January 2, 2014
File: 13143

RE: 118 on MUNJOY HILL

We have revised our project in response to comments from our neighbors, City Staff, and the Planning Board. Our changes include:

**L1.0**

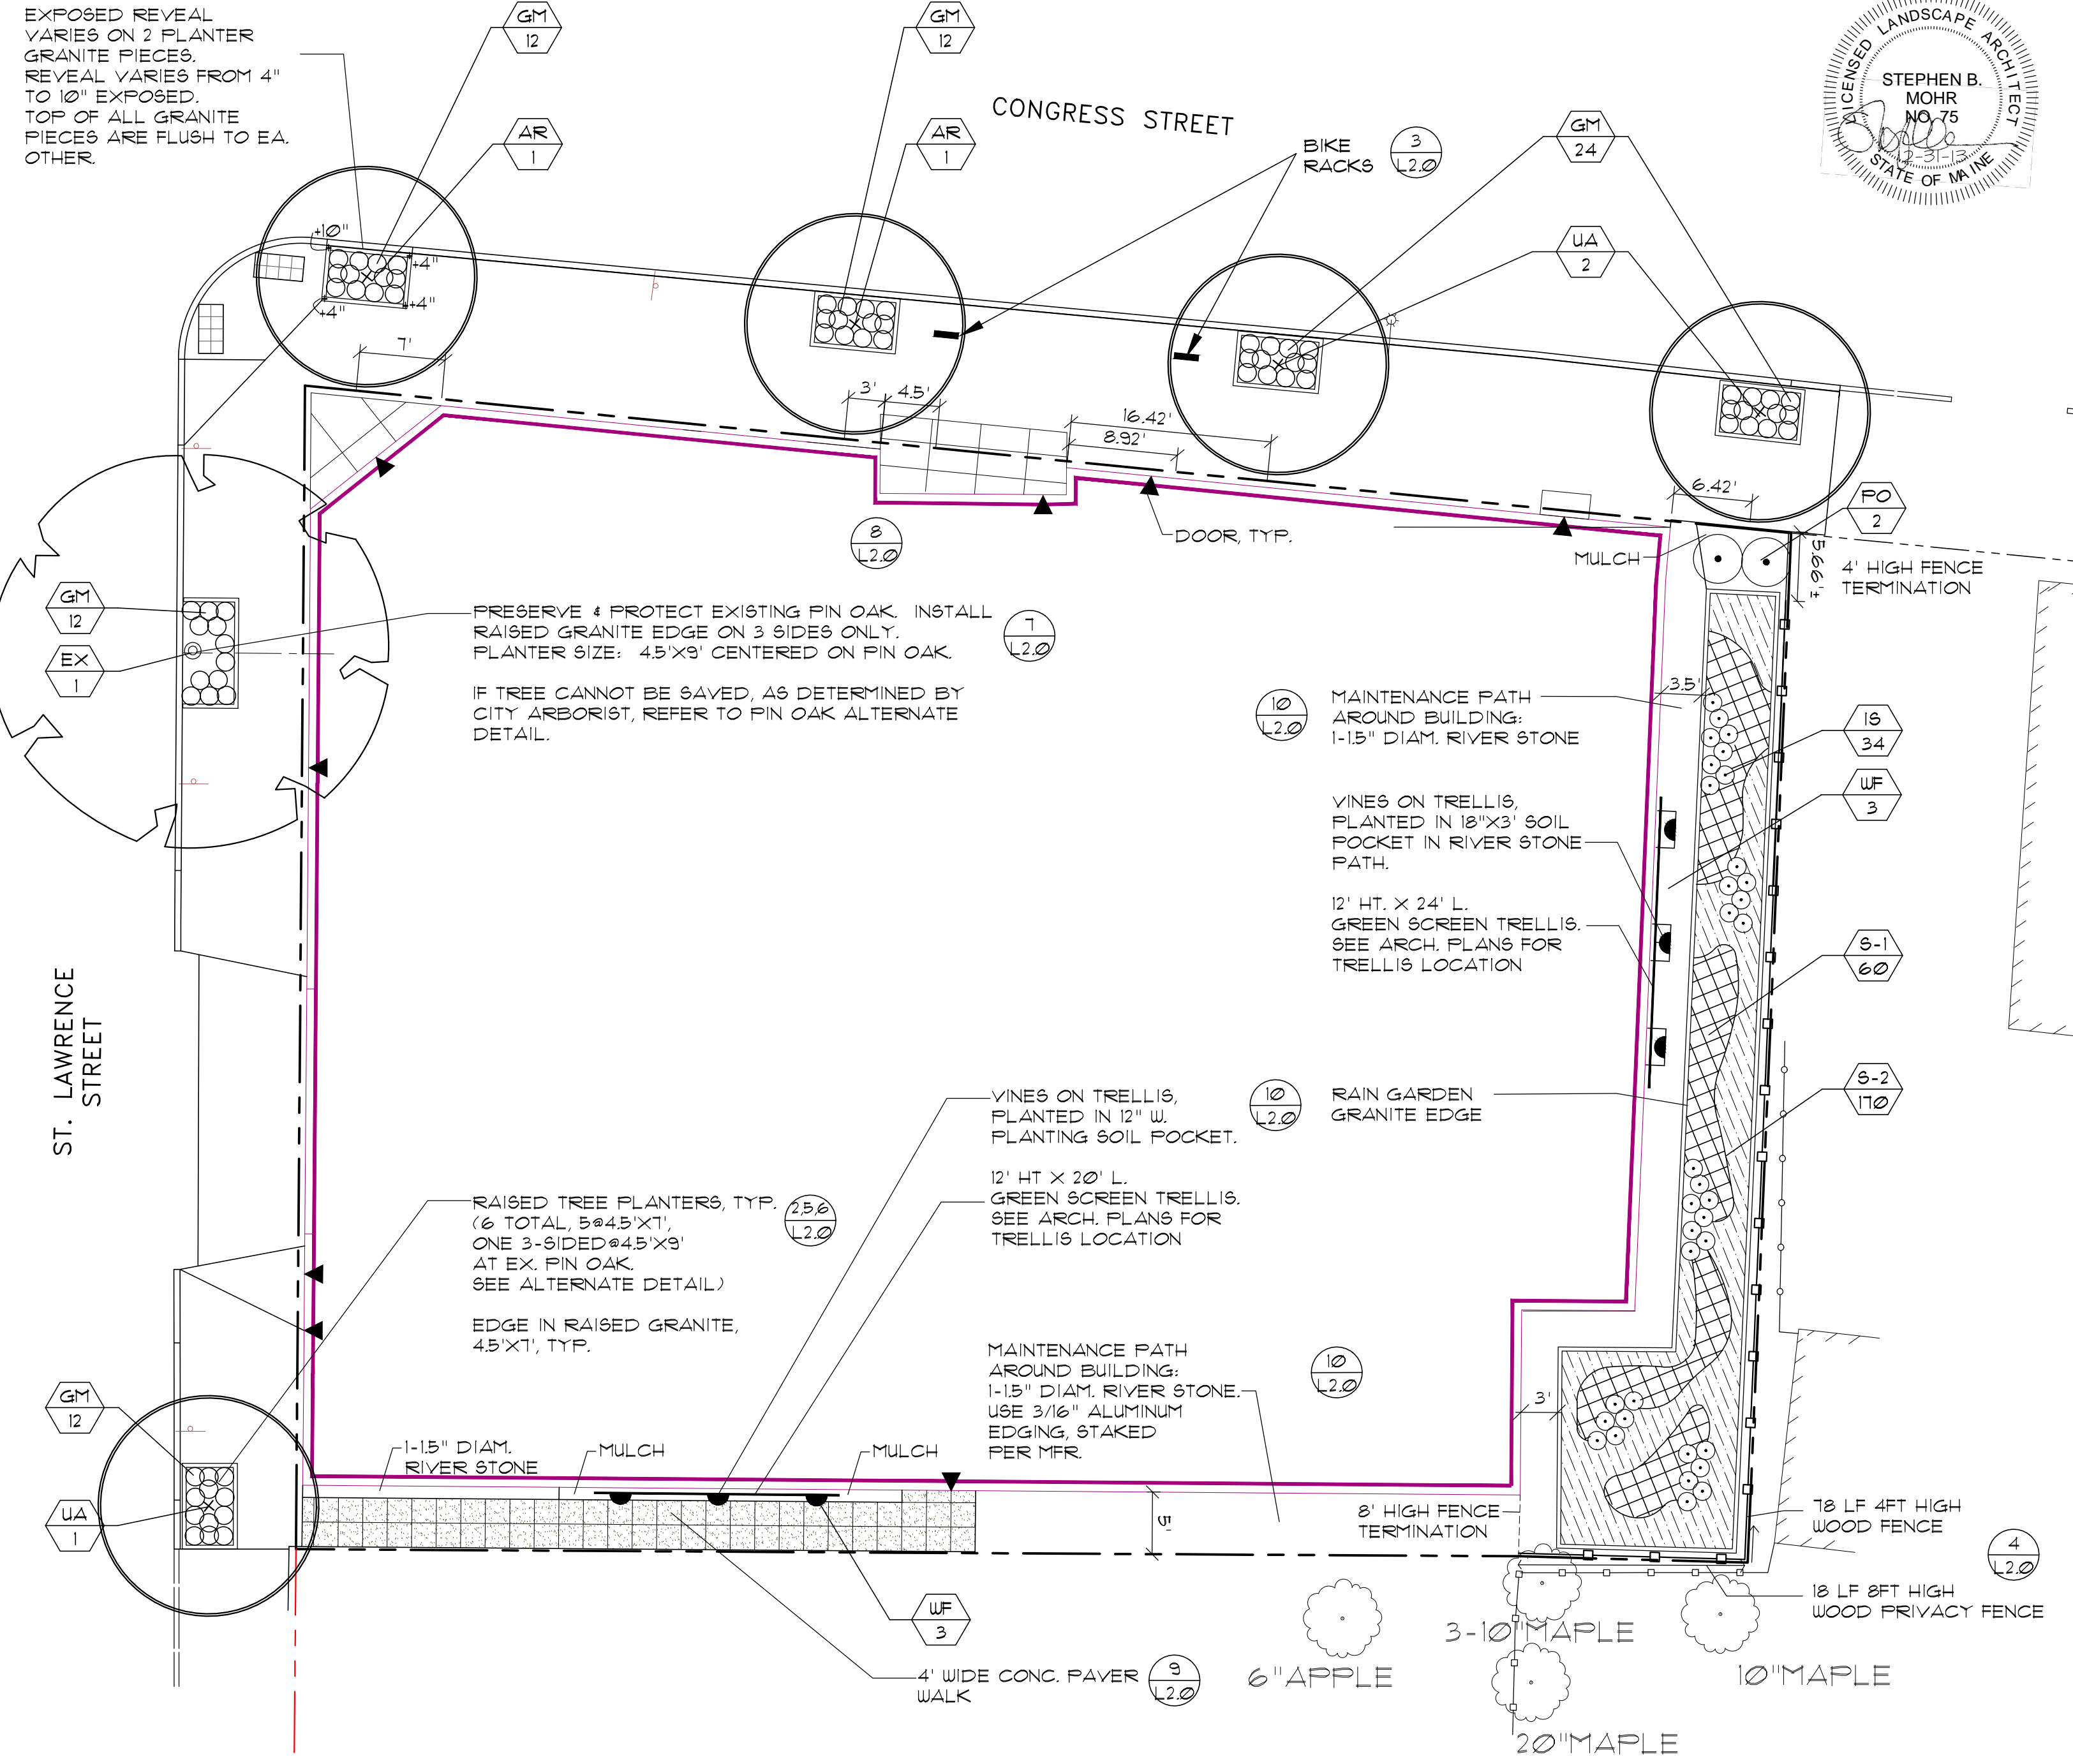
1. Revised Landscape in collaboration with Jeff Tarling.
2. Narrowing the building, so the Congress Street side is stepped back from the right-of-way by 1 foot. This requires a waiver of the parking standards.
3. Revised rear and side elevations with additional articulation. New graphics to provide a better understanding have been provided.
4. Revised stormwater management system to provide detention of roof water prior to discharge to the sewer and removal of the footing drains.
